Recommendation Report for Planning Permission for Works or Extension to a Dwelling

REF NO: BE/85/20/HH

LOCATION: 95 Sunningdale Gardens
 North Bersted
 Bognor Regis
 PO22 9LE

PROPOSAL: 2 storey side extension and single storey rear extension

Proposed Elevations, Plans and Section

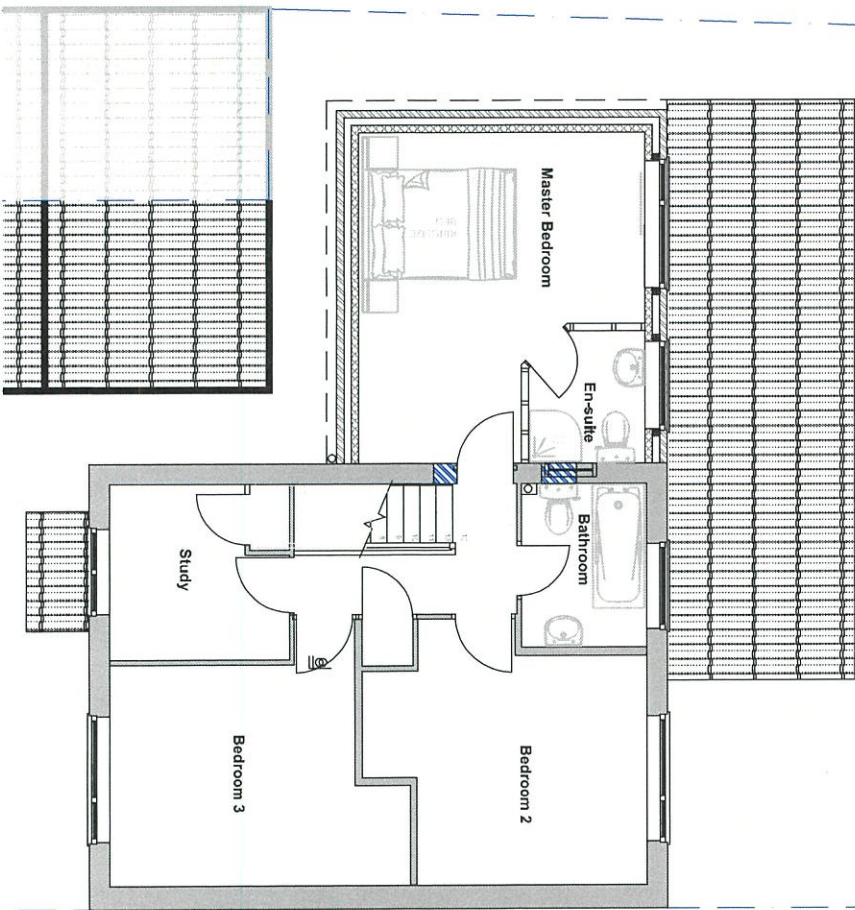
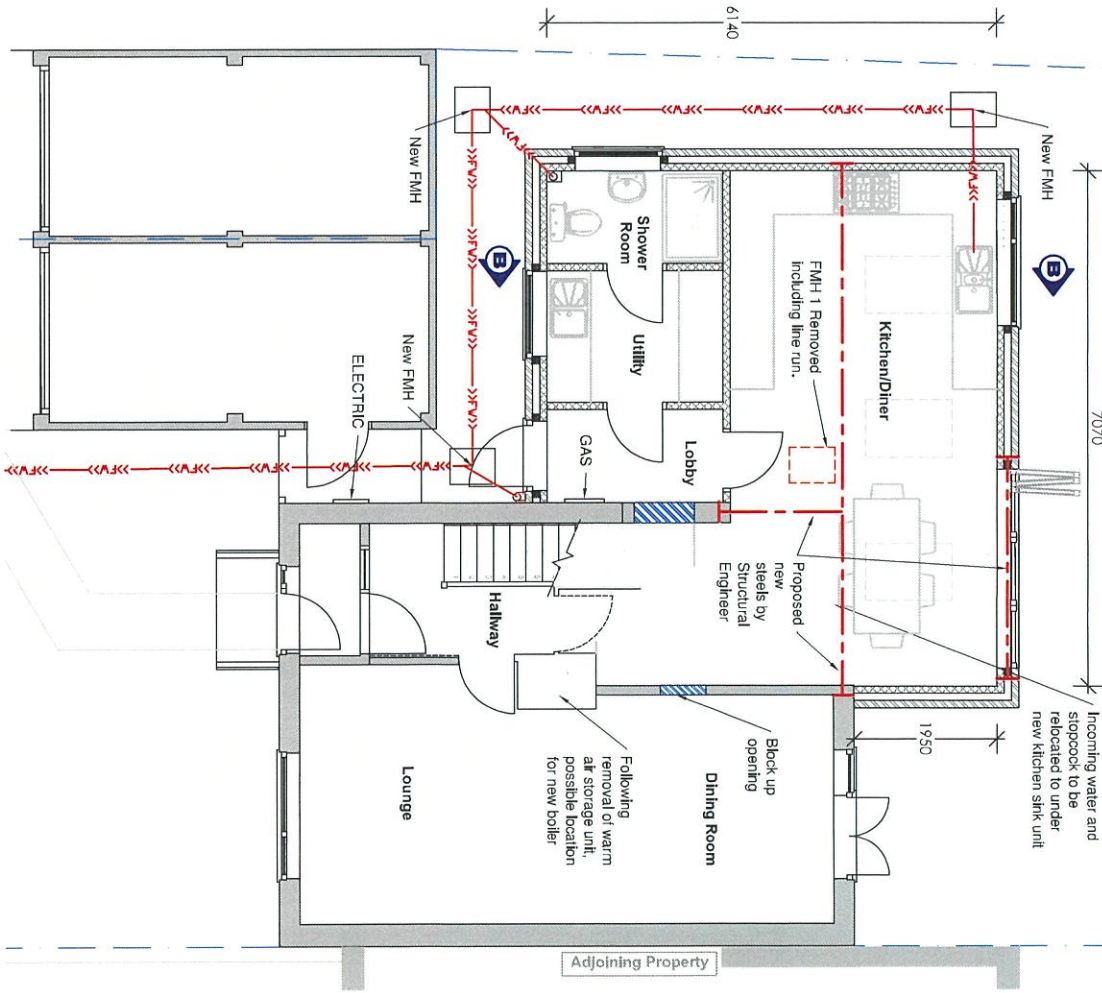
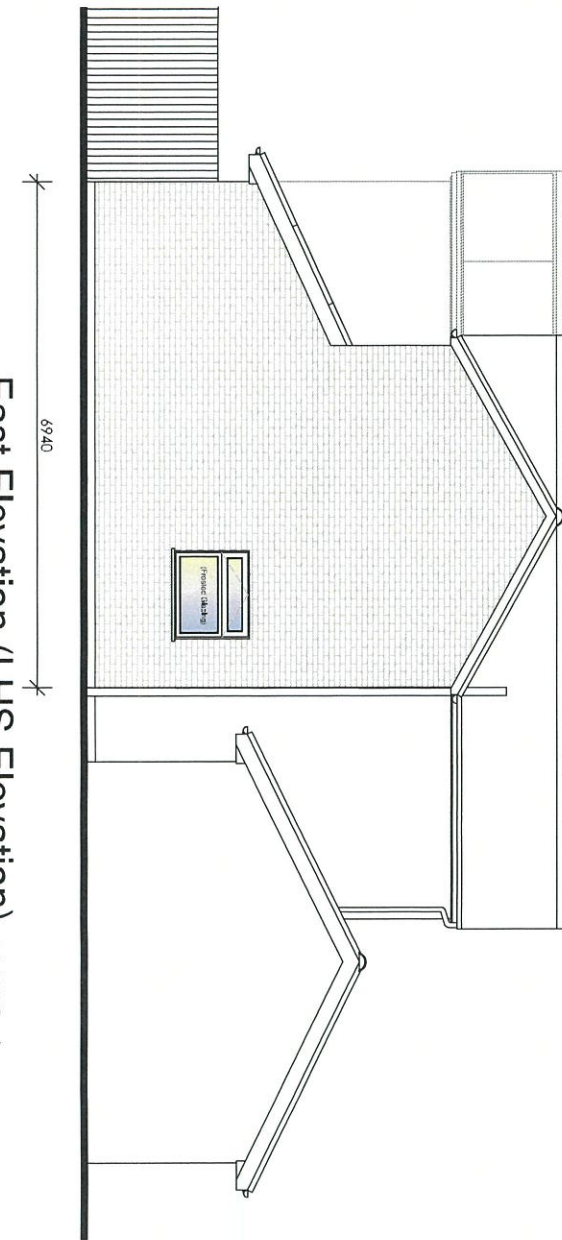
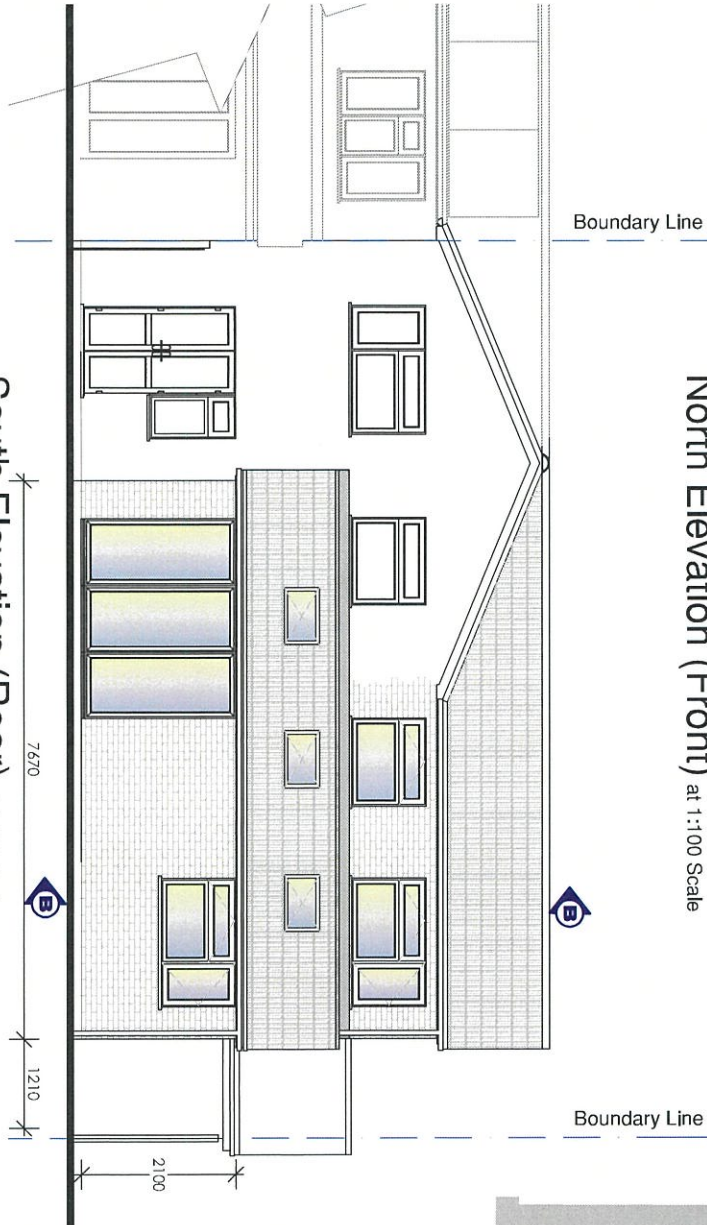
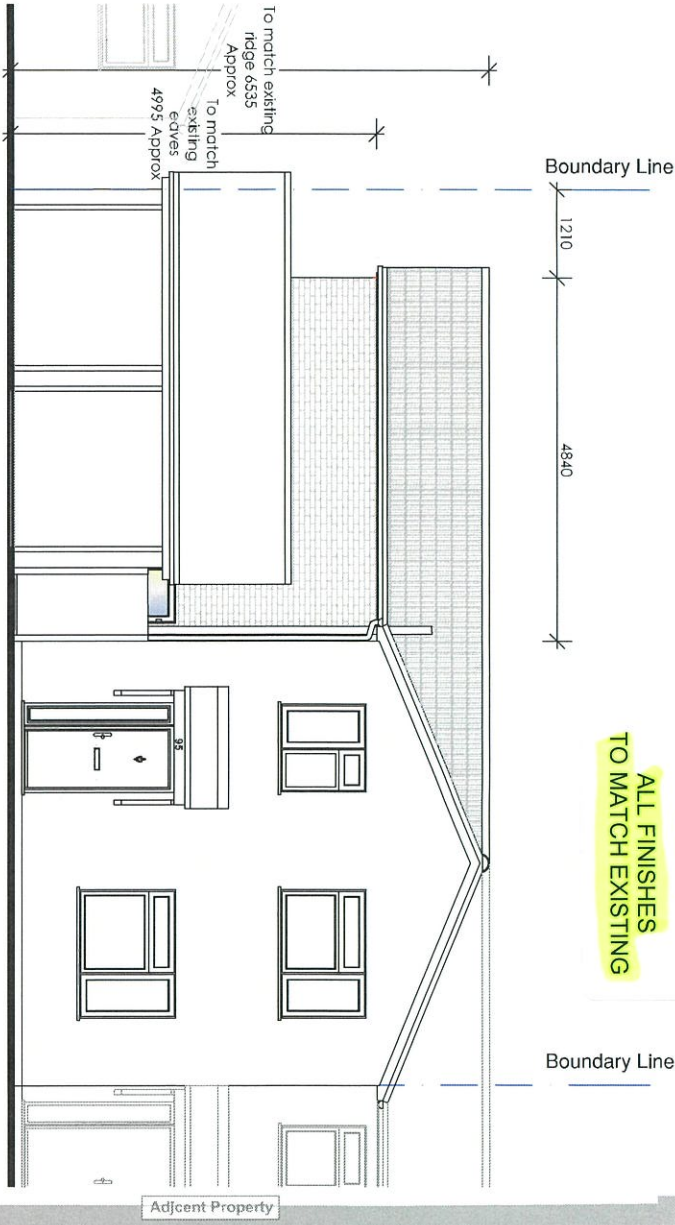
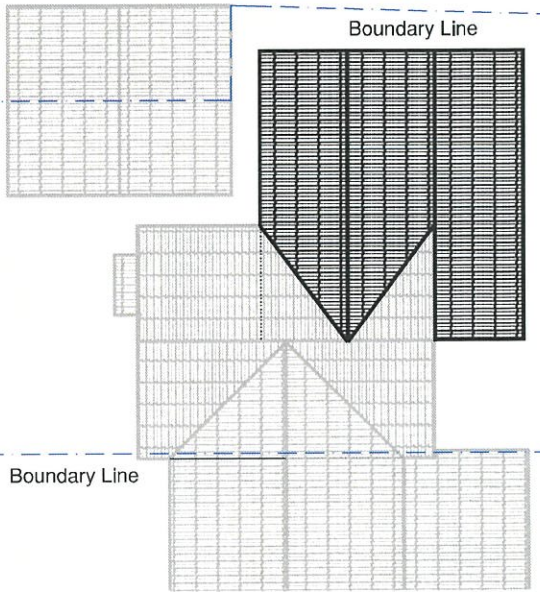
The proposal seeks to add a two storey side extension that will measure approximately 5m at eaves and have a ridge height of approximately 6m to match that of the existing dwelling house. Due to the scale of the proposal it is not considered to be subservient to the property but it is not deemed to have a demonstrably harmful visual impact as there are other examples of extensions which are visible from the street scene in Sunningdale Gardens. The inclusion of materials to match the existing dwelling allow the extension to be sympathetic to the street scene without dominating it.

The proposal will have a depth of 6.14m and width of 7.7m at the ground floor with the first floor addition measuring 4.37m in depth and 4.65m in width. The ground floor aspect of the application is to have three skylights in the roof with sliding doors and a window to the rear which serve the rear garden of the property.

The addition extends beyond the rear elevation of the neighbouring property, however due to the siting of the proposal it does not intersect a 45 degree angle. Whilst the extension is a large addition to the site it is not considered to cause overlooking as the windows are situated to the rear of the extension looking out over the garden, with the only windows looking to the east being on the ground floor. The two additional windows to the eastern portion of the extension brings overlooking closer to the immediate neighbour but this elevation is still set back from the neighbour reducing the harm. Furthermore the distance from the rear boundary is at 8.4m with the side boundary being 1.2m away the overbearing aspect of the proposal is considered to be mitigated as there is sufficient distance to ensure the proposal does not encroach on the boundary and the enjoyment of the rear garden of the neighbouring property #93 Sunningdale Gardens. This is in part due to the orientation of the buildings and the relative depth of the neighbouring properties.

The proposal is not considered to harm amenity by way of overbearing, overshadowing or overlooking and accord with D DM1 and D DM4 of the Arun Local Plan.
